Re: Response to Submissions (RTS) for Burrah Park (SSD-70316465) – Species polygon application

This letter has been prepared in response to advice received from CPHR, in response to the State Significant Development (SSD) SSD-70316465 known as Burrah Park. The SSD is located at 1953-2109 Elizabeth Drive, Badgerys Creek NSW and is available at [Major Projects](#).

Table 1: CPHR Advice (Species polygons)

Figure 14: Species polygon for Cumberland Plain land Snail, *Pultenaea parviflora* and *Hibbertia* sp. Bankstown recorded within the development footprint

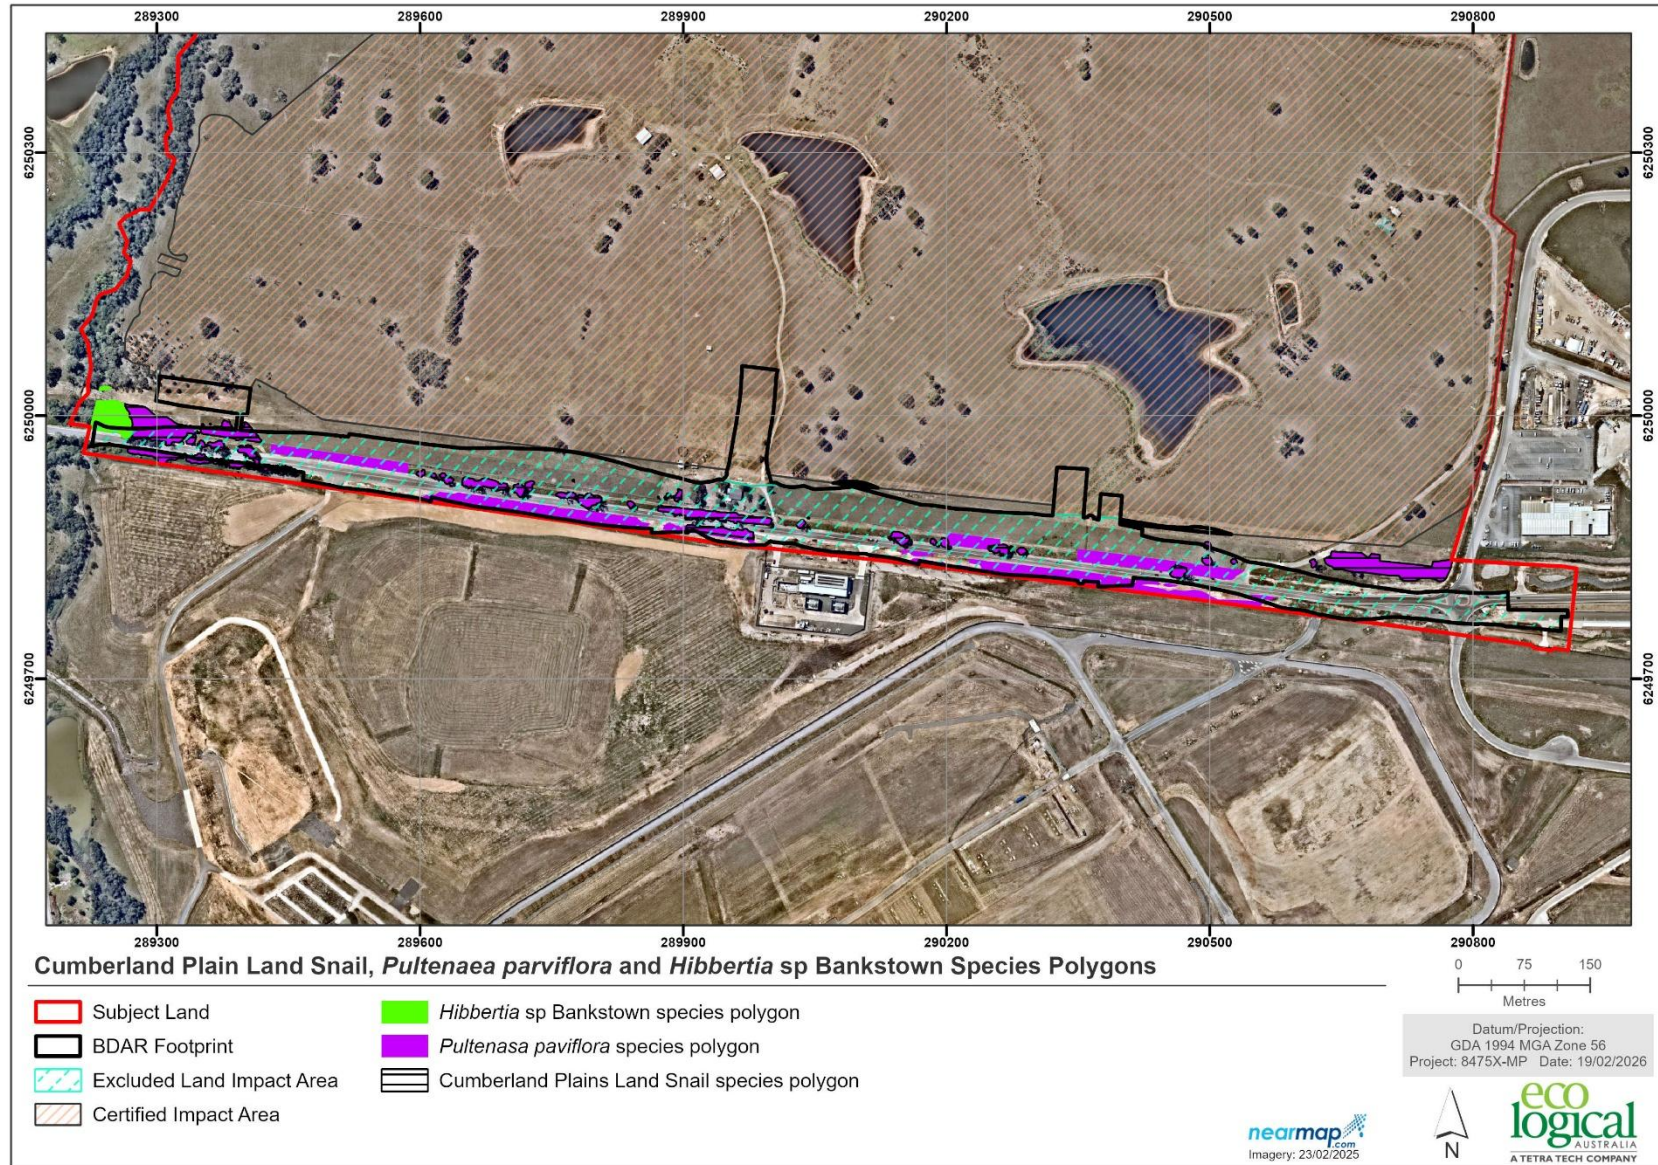
With reference to both the Biodiversity Assessment Method (BAM) 2020 and the BAM 2017, the interpretation and reasoning of the BDAR application of threatened species polygons is provided below in Table 2. Two species polygons in the BDAR exclude low Vegetation Integrity (VI) scored vegetation in the form of PCT 3320 DNG and exotic vegetation in accordance with the BAM. The species relevant to this response are Southern Myotis (*Myotis macropus*) *Pultenaea parviflora*.

The BAM does not require offsets to be generated for impacts to threatened species habitat when the VI score of the zone is less than 17. Considering that the PCT 3320-DNG vegetation zone has a VI score of 10.2, offsets should not apply and therefore the species polygon should not extend to include these areas. Exotic vegetation areas have been excluded from a species polygon and assessed in accordance with Section 6 of the BAM (prescribed impacts).

It is therefore our interpretation that the species polygons have been correctly applied and inclusion of low VI score vegetation requires no further assessment or offset beyond a prescribed impact assessment. The discussion in this letter addresses the approach as set out by the BAM.

Figure 15: Species polygon for Southern Myotis previously recorded within the development footprint

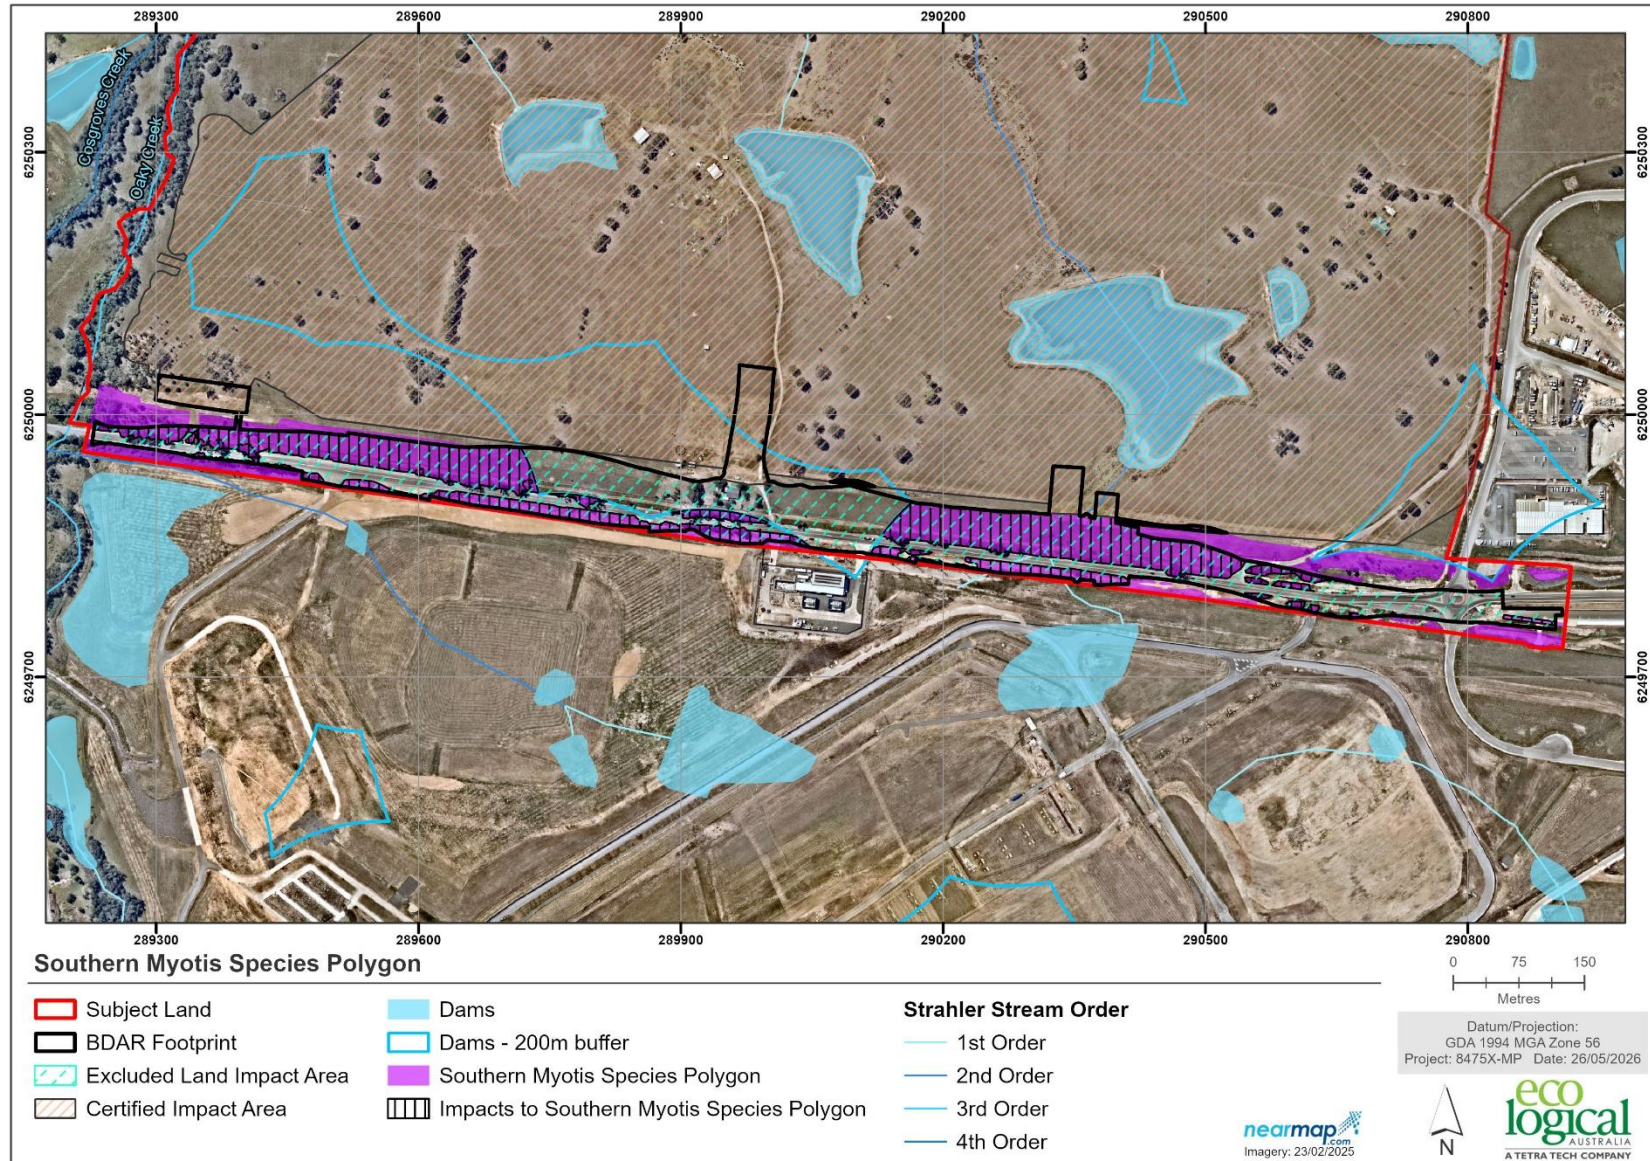
Relevant species	CPHR Advice
Southern Myotis	<p>The species polygon for Southern Myotis (<i>Myotis macropus</i>) incorrectly excludes PCT 3320-DNG and exotic grassland due to the vegetation integrity (VI) Score. Southern Myotis habitat is not dependent on the vegetation integrity.</p> <p>Section 9.2.2 (1) of the BAM only applies to threatened species assessed for ecosystem credits. The VI score cannot be used to determine the requirement to offset species credit species. In accordance with 9.2.2(2), offsets should be determined for species credit species based on habitat constraints or polygon requirements detailed within the NSW BioNet TBDC and approved survey guides.</p>
<i>Pultenaea parviflora</i>	<p>Section 9.2.2(1) of the BAM only applies to threatened species assessed for ecosystem credits. VI score cannot be used to determine the requirement to offset species credit species. In accordance with 9.2.2(2), offsets should be determined for species credit species based on habitat constraints or polygon requirements detailed within the NSW BioNet TBDC and approved survey guides.</p> <p><i>Pultenaea parviflora</i> is an area species under the BAM. As such, the species polygon is required to incorporate all suitable habitat for the species, regardless of whether individuals were identified at the time of survey, noting targeted surveys were not completed. Additionally, <i>Pultenaea parviflora</i> is a coloniser species which will readily establish after disturbance. No evidence of habitat constraints has been identified within PCT 3320-DNG for this species.</p>
